# Council for British Archaeology

8<sup>th</sup> February 2019

**Duke of York Inn, Grindleton Brow, Grindleton, Clitheroe, Lancashire, BB7 4QR. Application No. 3/2019/0050**

Drawing Title
PROPOSED GARAGE PLANS, SECTIONS AND ELEVATIONS

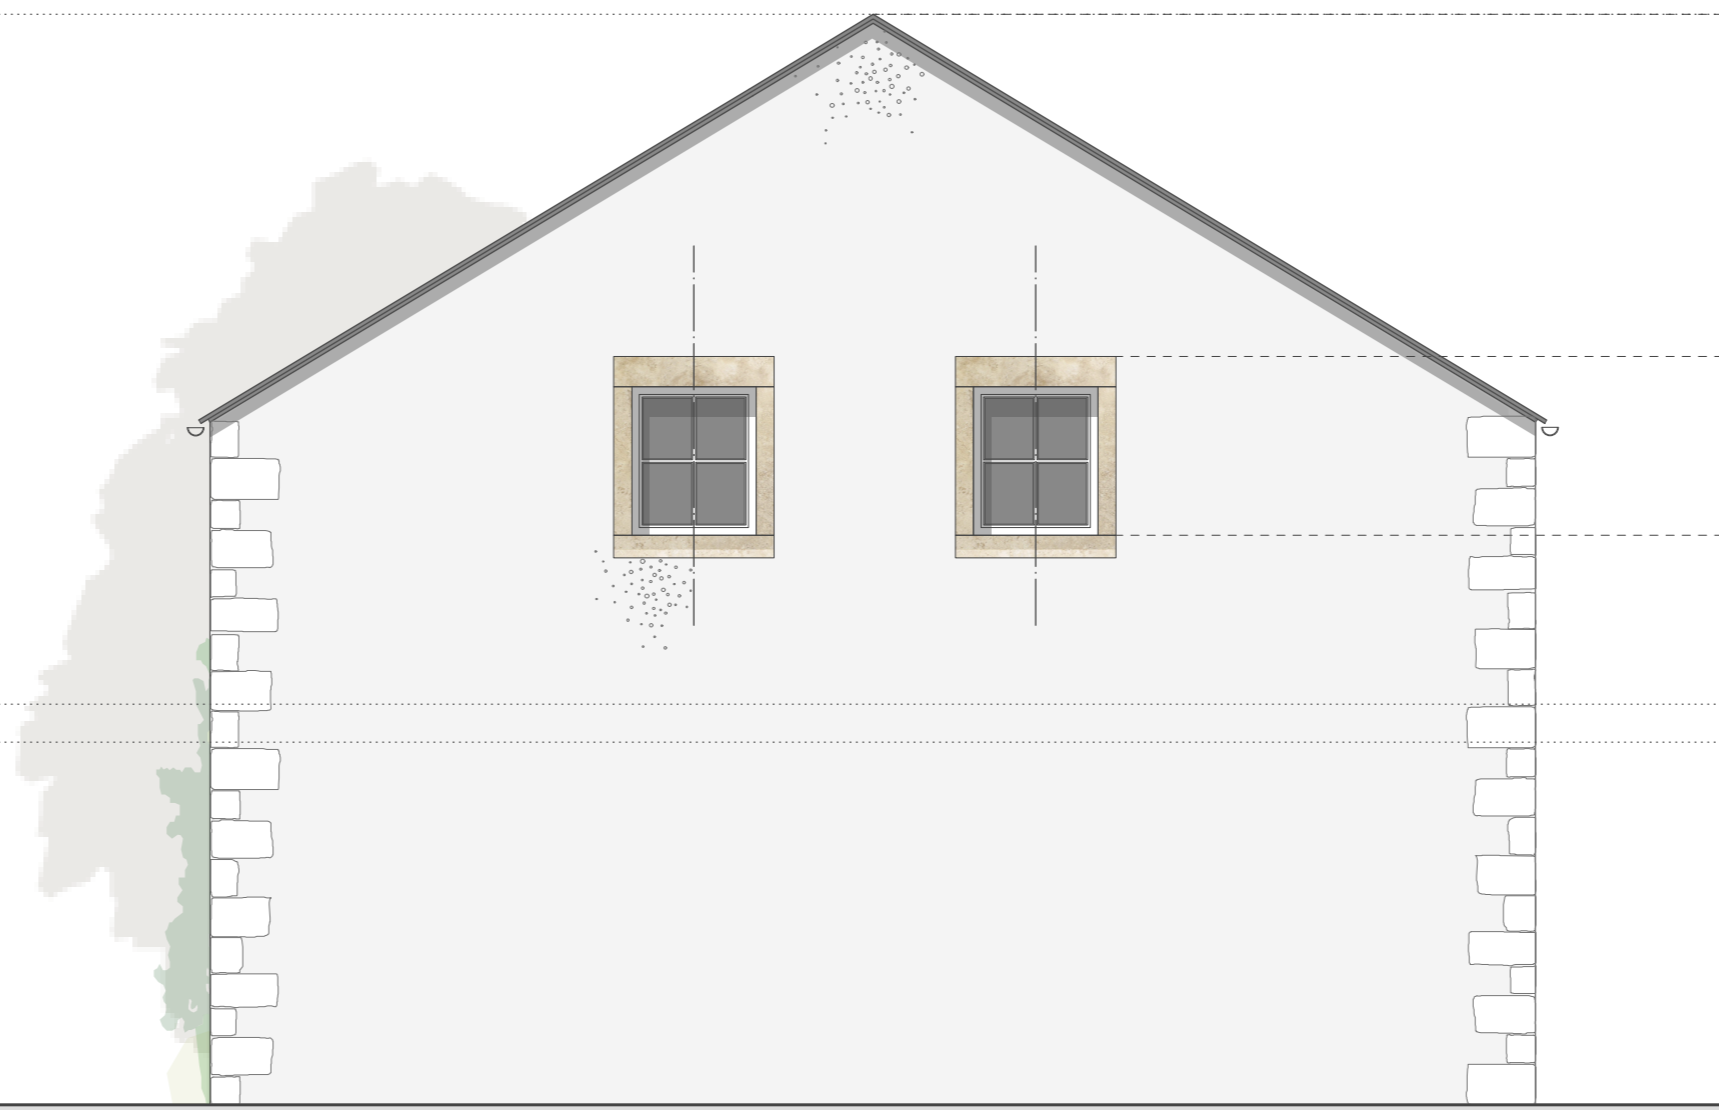
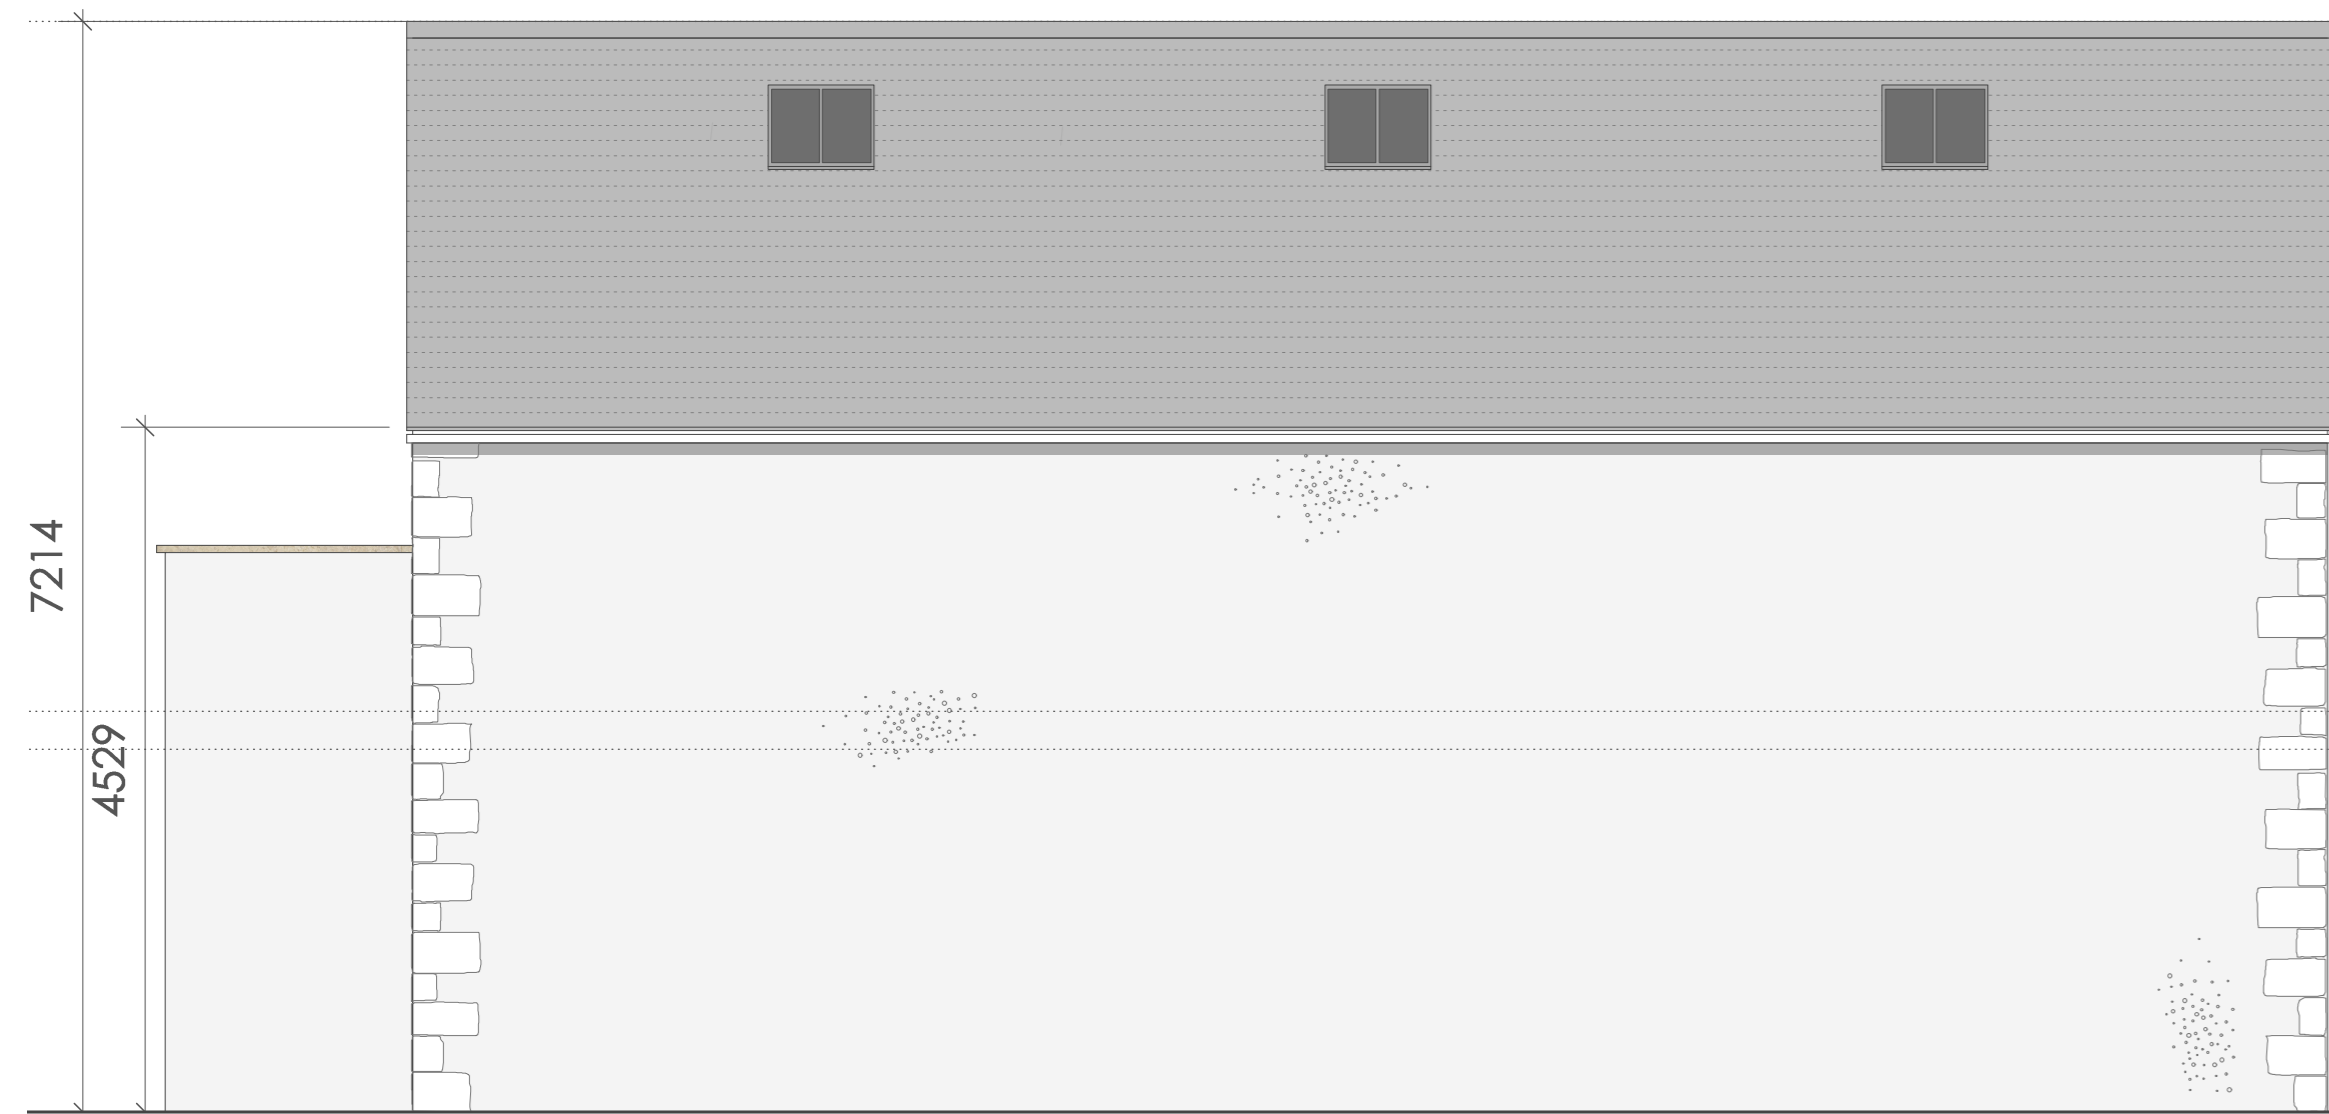
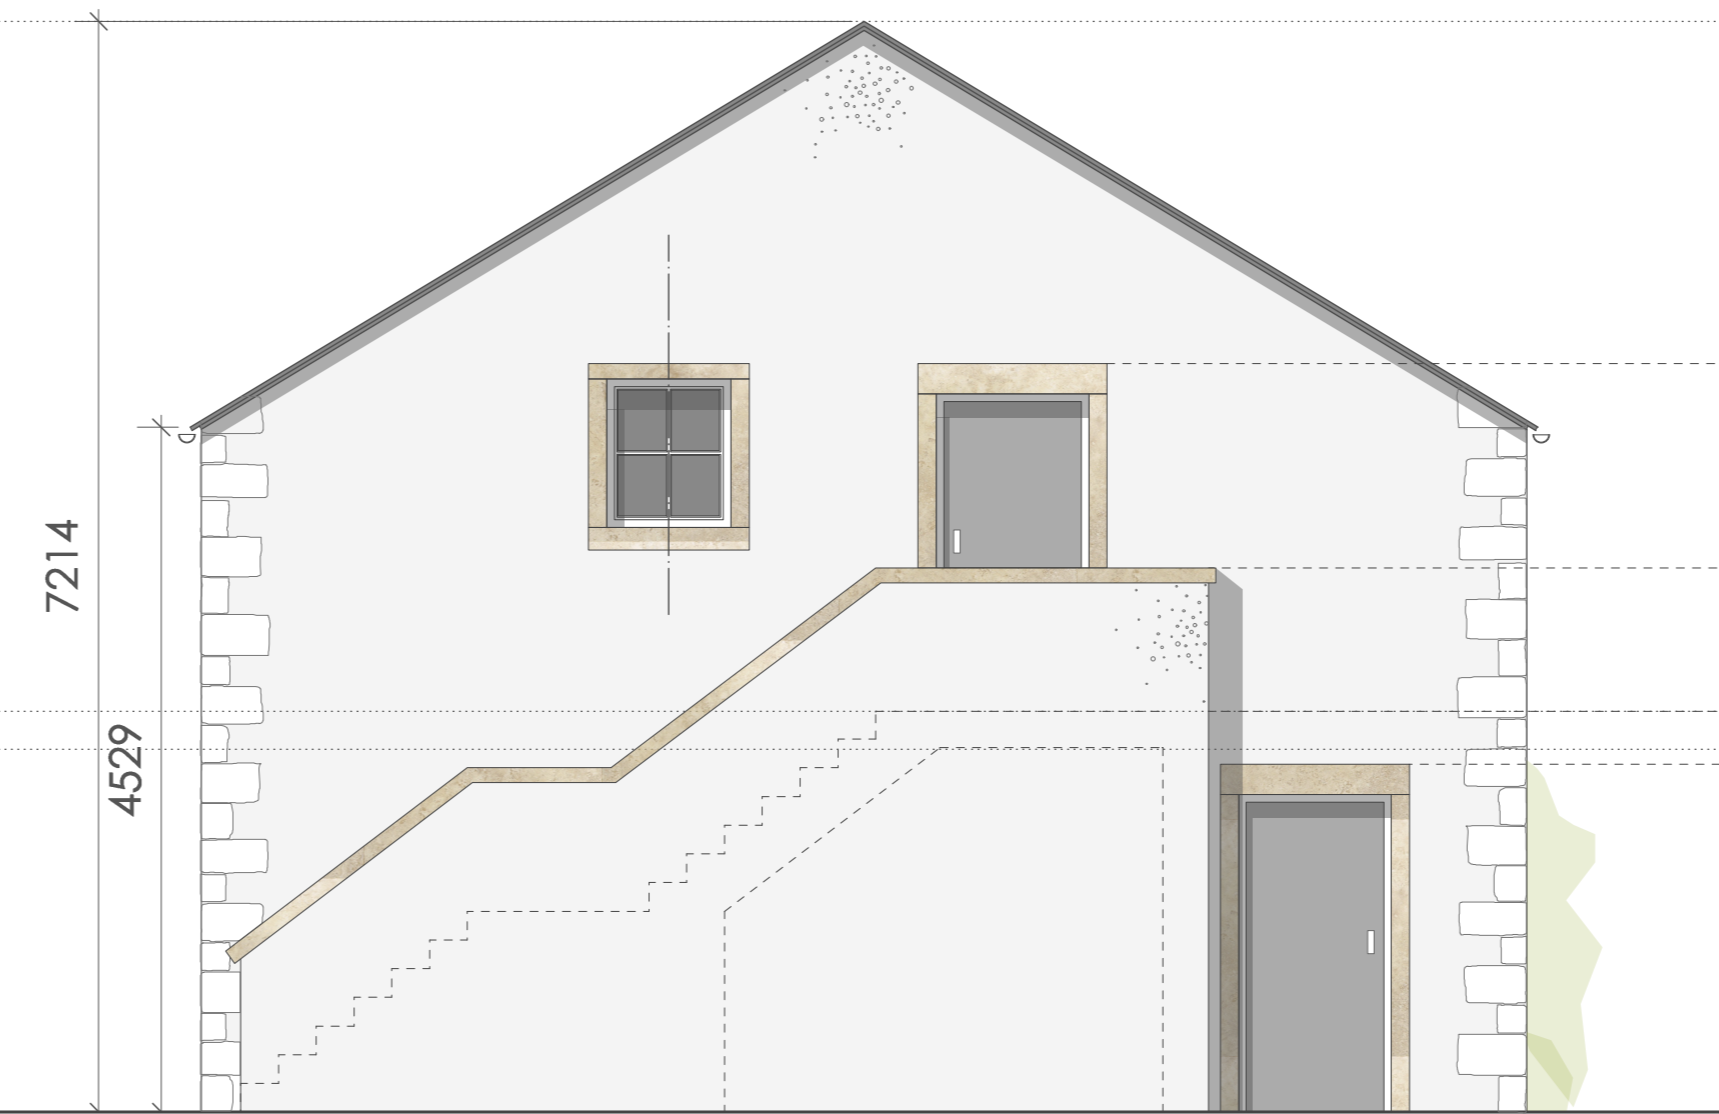
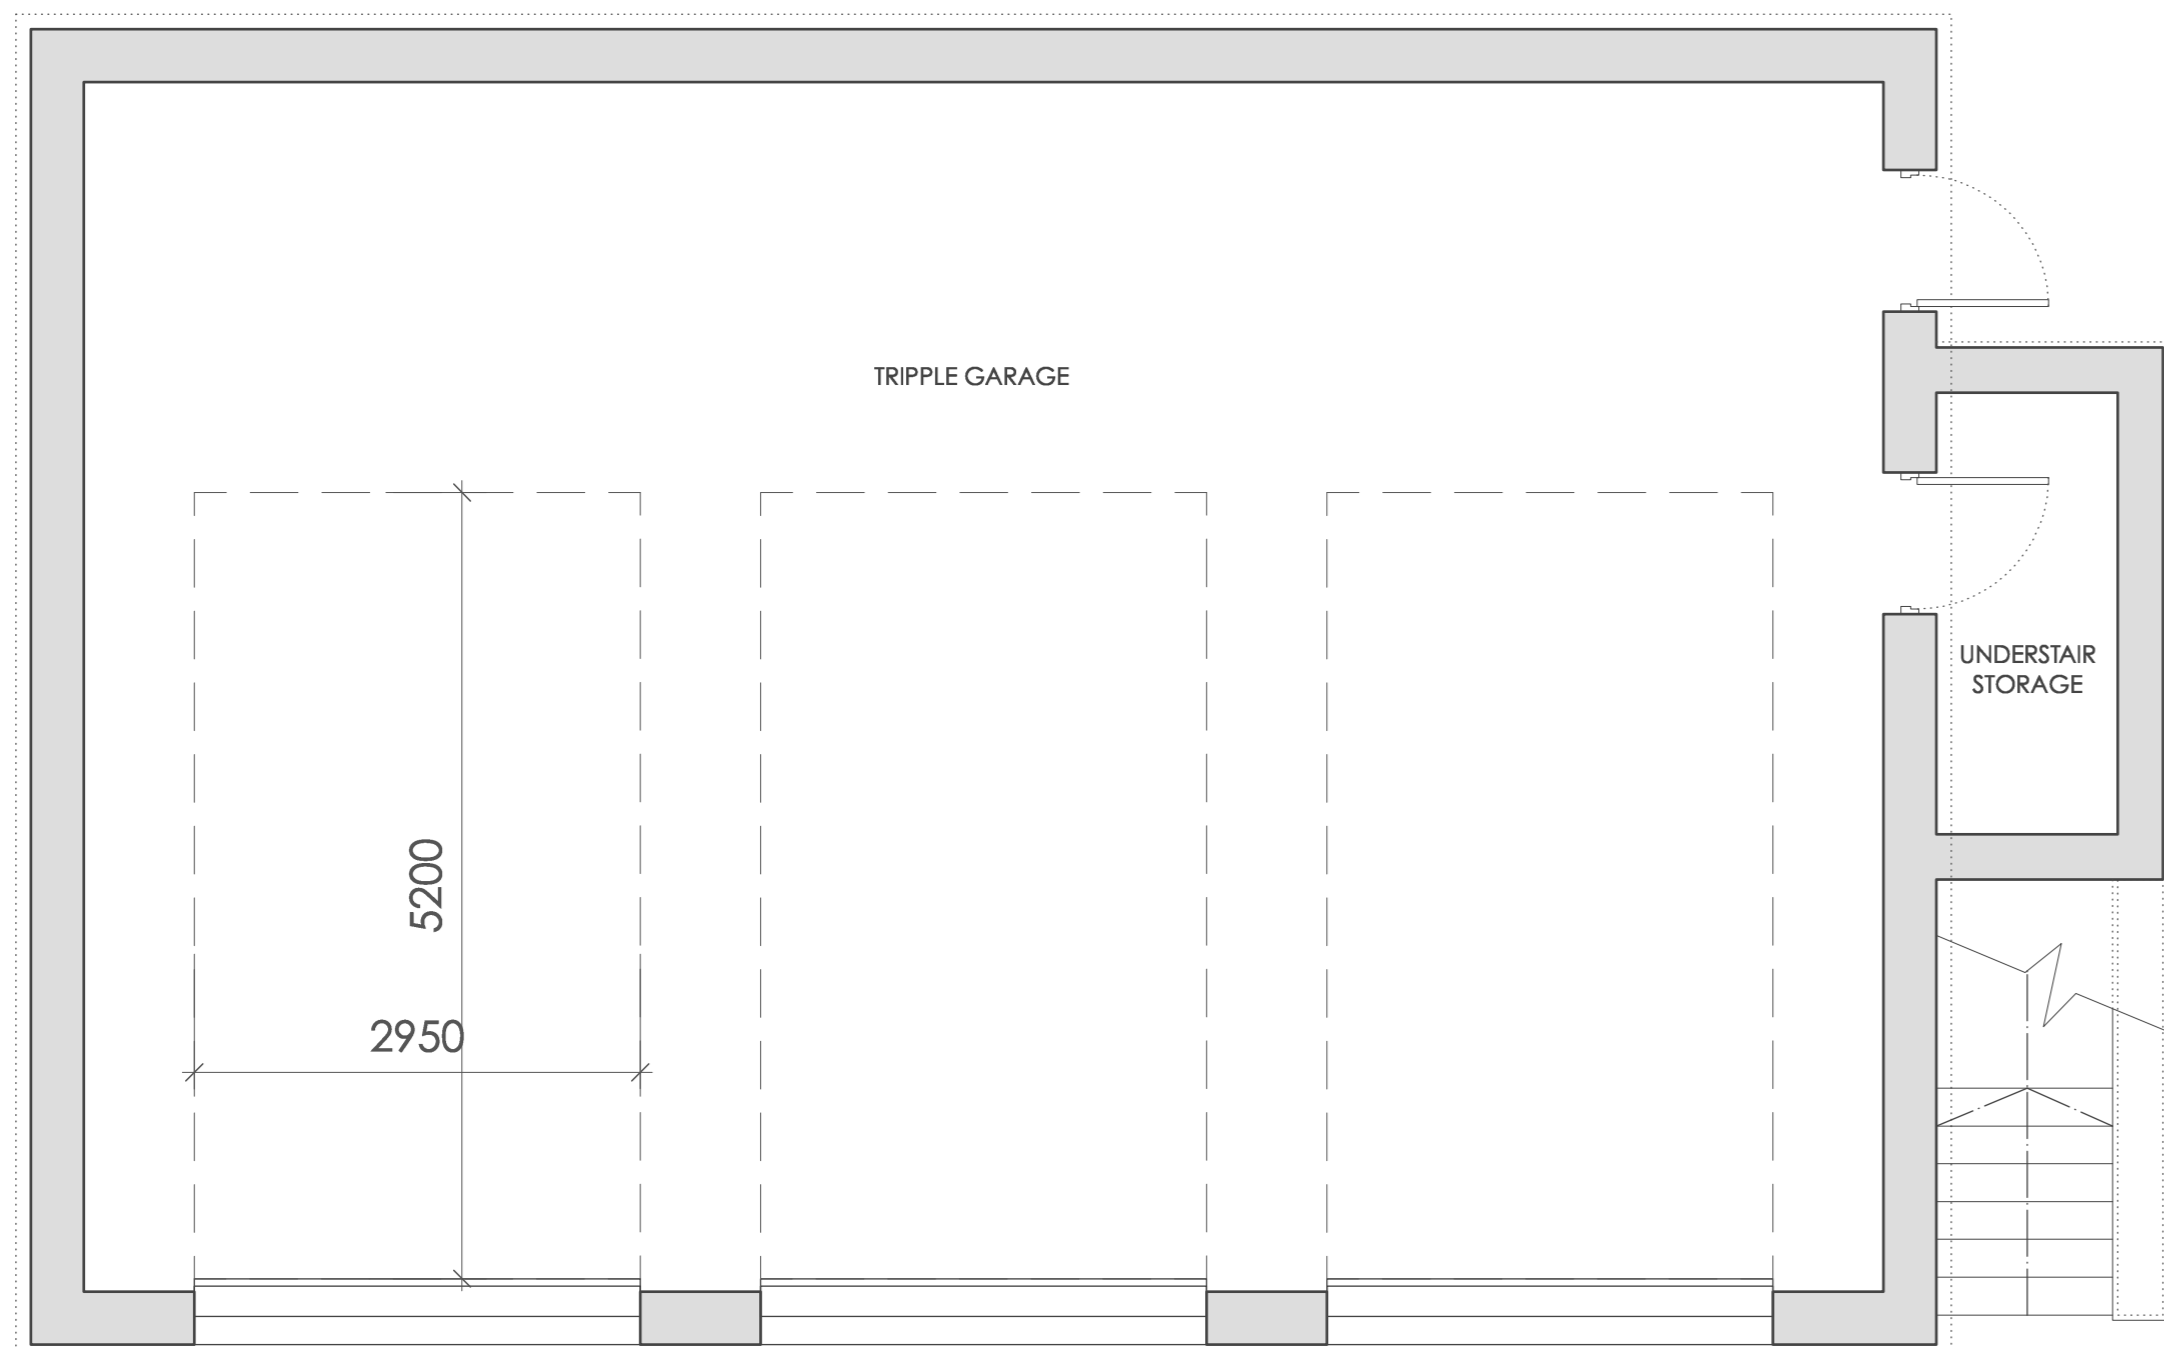
Having examined the plans, elevations and single visualisation for the proposed new builds and associated access, landscaping and garaging, we conclude that the proposed cottages and associated works will result in a substantial change to the setting of both the Listed Grade II Duke of York Inn and the Grindleton Conservation Area. The setting of the Inn will be heavily compromised by the new frontage building and the redesigned site access. The status of the Inn as a Focal Building at a gateway location to the conservation area will be challenged to the extent that from Brow Hill at least the Inn will no longer 'stand out'. We consider this to be *"harm"* as defined in the NPPF. Whether this impact on the setting of both designated heritage assets would amount to *"substantial harm"* or *"less than substantial harm"* may not be the issue.

The absence of an appropriate assessment of significance notwithstanding, the CBA considers the design, scale and massing of the proposed new builds to be out of character. The main new build against Brow Hill is set forward from the Duke of York Inn and is far too large to successfully respect the character and appearance of the Conservation Area and the setting of the Listed Grade II Duke of York Inn. The proposed gable, for instance, introduces a design element that is not reflected in any other buildings within the immediate area.
